Ribble Valley Borough Council
Council Offices
Church Walk,
Clitheroe
Lancashire
BB7 2RA

Phone: 0300 123 6780
Email: Kathryn.Walsh@lancashire.gov.uk
Your ref: 3/2024/0969
Our ref: 3/2024/0969/HDC/KW
Date: 20 December 2024

Location: 24 Durham Road Wilpshire BB1 9LR
Proposal: Proposed change of use from garage/workshop to commercial art studio and pottery for producing, stocking, selling online and teaching small groups (up to 6 at a time) three times per week.
Grid Ref: 369008 433108

Client: Marion Walsh		
Project: Proposed Alterations 24 Dunham Road Wilpshire		
Dwg title: Existing Site Plan		
Scale @ A4: 1:200	Date: 04.12.24	Drawn by: PD
Drawing no. 1682 - 101	Rev. -

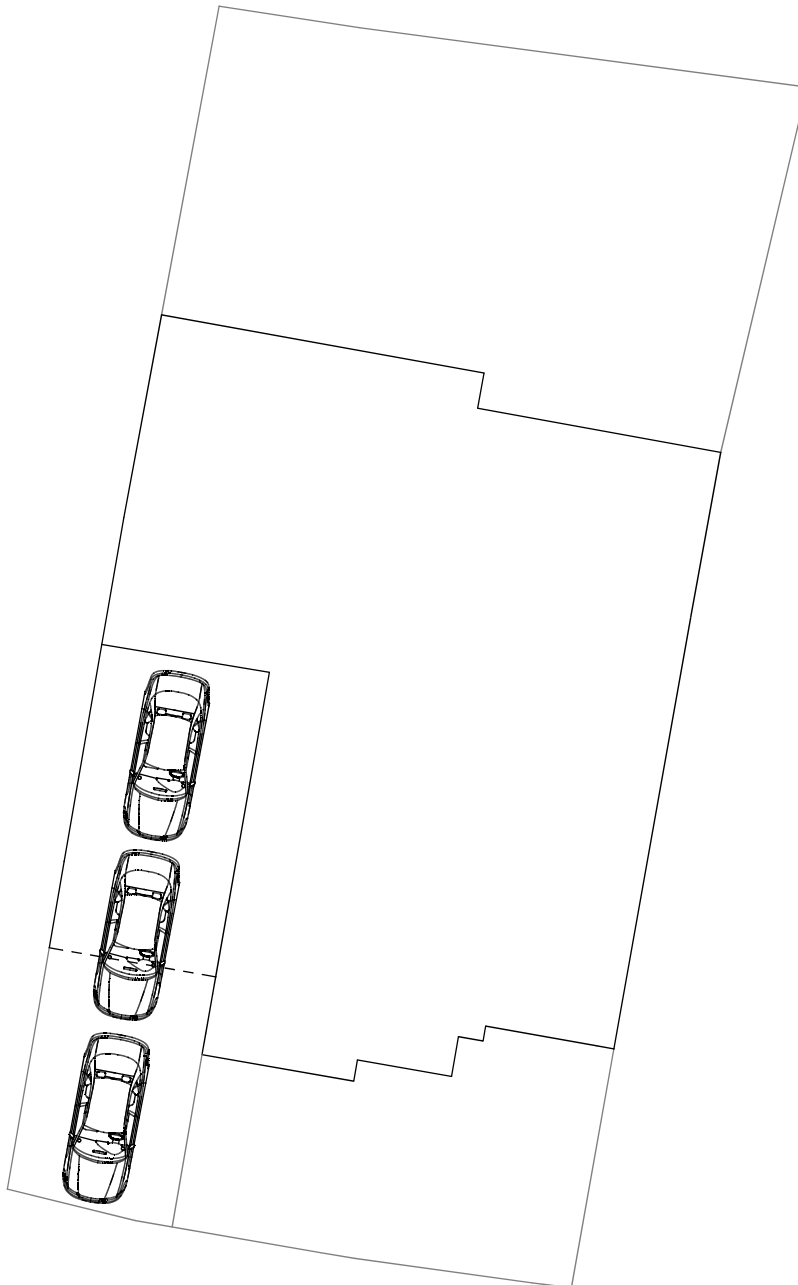
The development is to retain the existing dwelling use plus add commercial use within a converted garage/workshop. No information has been provided which detail the parking requirements for the dwelling. The applicant should provide information about how many bedrooms there are within the dwelling, which will enable the LHA to assess the parking need that must be retained. From records it appears the dwelling is a 4-bedroom dwelling, therefore 3 off street parking spaces should be maintained within the site to serve the dwelling.

It is expected that the site not only provides off-street parking for the existing dwelling but also for the proposed development. As the applicant has provided the number of clients expected to attend classes, the LHA would look for a parking plan which meets not only the off-street parking provisions for the dwelling but also independently for the 6 clients expected to attend the site.

The client makes note of on-street parking within the highway in the cover letter provided. However, the LHA have concerns regarding the volume of on-street parking around the junction of Shropshire Drive and Durham Road. As well as the suggested location close to the playing field entrance however the LHA would have concerns over pavement parking in this location as the area should provide free-flowing pedestrian movement given the fact the park is likely to be used by more vulnerable road users such as children. This road also would not support parking due to its width and should remain clear for manoeuvring.
